## MMC Congress Street Concept Plans

**From:** Nikki Scott <nscott@sebagotechnics.com>  
**Sent:** Thursday, February 6, 2020 10:18 AM  
**To:** Will Conway <wconway@sebagotechnics.com>  
**Cc:** Bradley Lyon <blyon@sebagotechnics.com>; Steve Sawyer <ssawyer@sebagotechnics.com>; 15466 <15466@sebagotechnics.com>  
**Subject:** 15466 Congress Street Concept Plans

Please see the attached concept plan for distribution to the Maine Medical Team. Additionally, please forward along our response to the City of Portland's comments below:

CONGRESS STREET

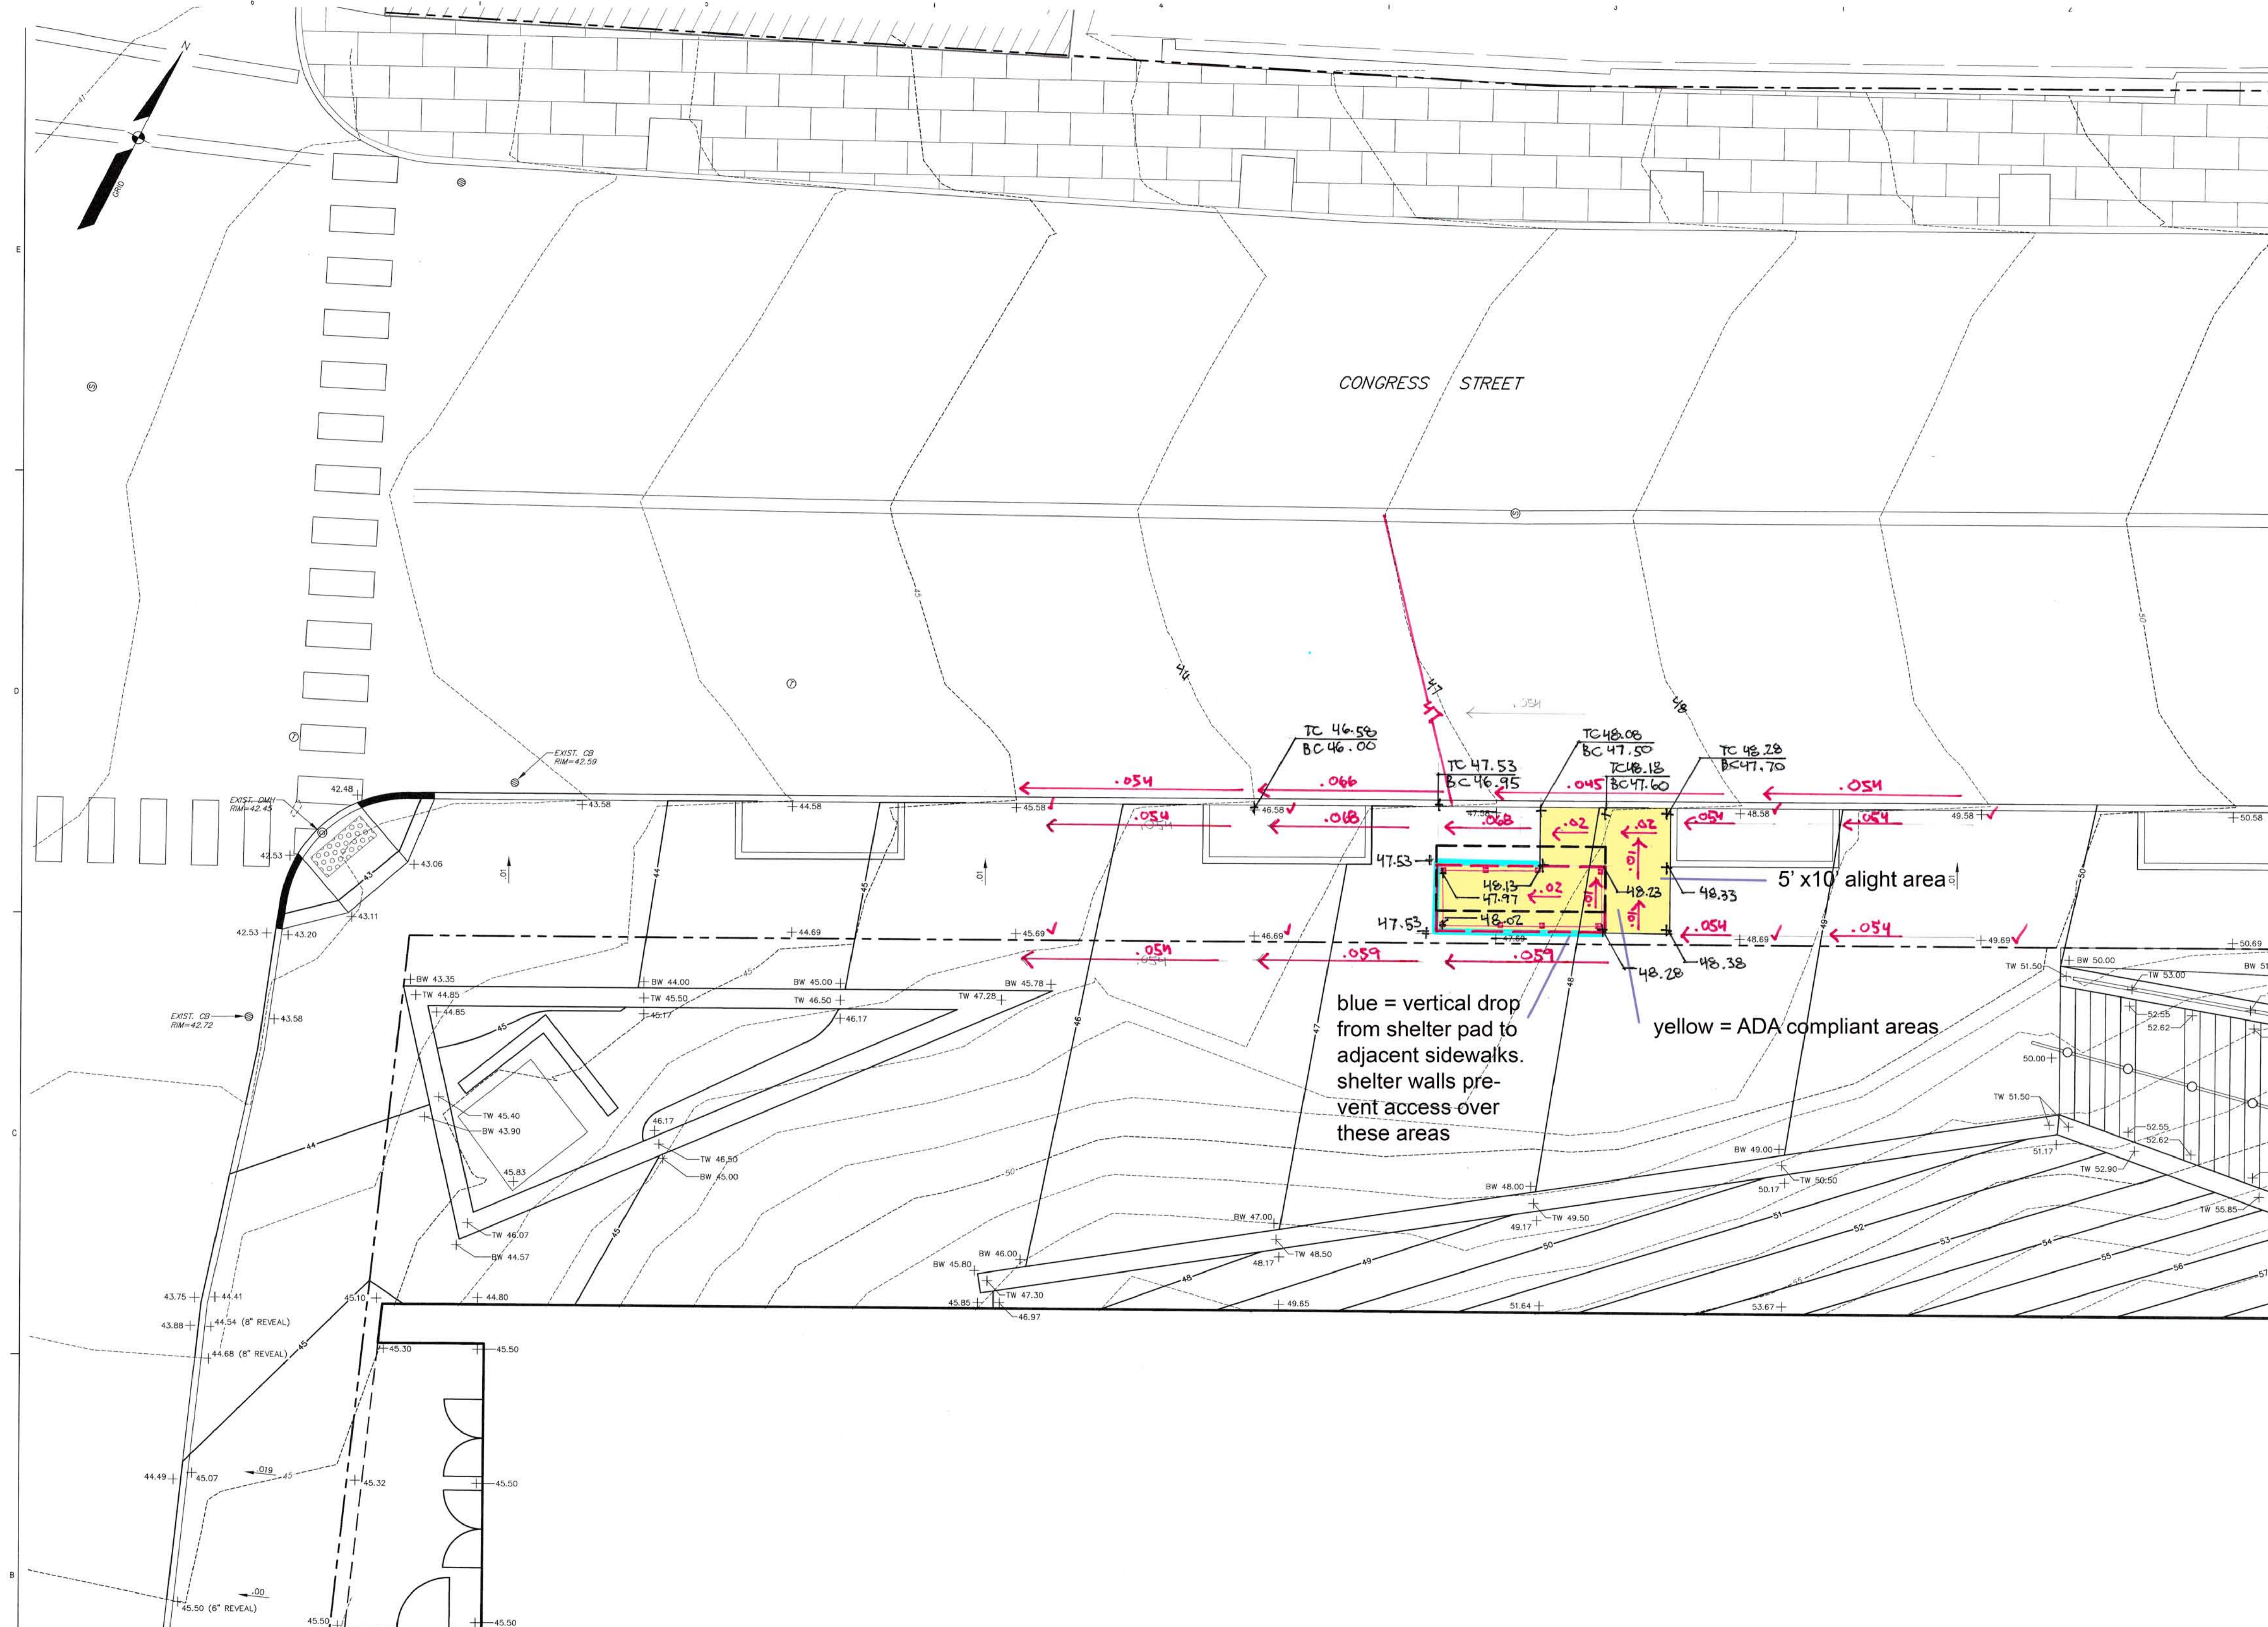
- The concept does not appear to reflect the work done up to the Planning Board's approval with conditions that include moving the southerly curb line of Congress Street from Gilman to the Visitor's Garage entrance out ~4' to enable the bus stop/bus shelter to be ADA compliant and have enough room behind the shelter for pedestrian access.

*We have altered the alignment to shift the southerly curb line in front of Maine Medical back to be more consistent to what was originally proposed. The bus shelter is now shown on our plans with 5' of clearance from the face of the shelter to the back edge of the curb. The resulting dimension from the ROW line to the back of the shelter is 2.2' with this modification. It is our understanding that MMC is providing the City a sidewalk easement that allows ample pedestrian access behind this shelter.*
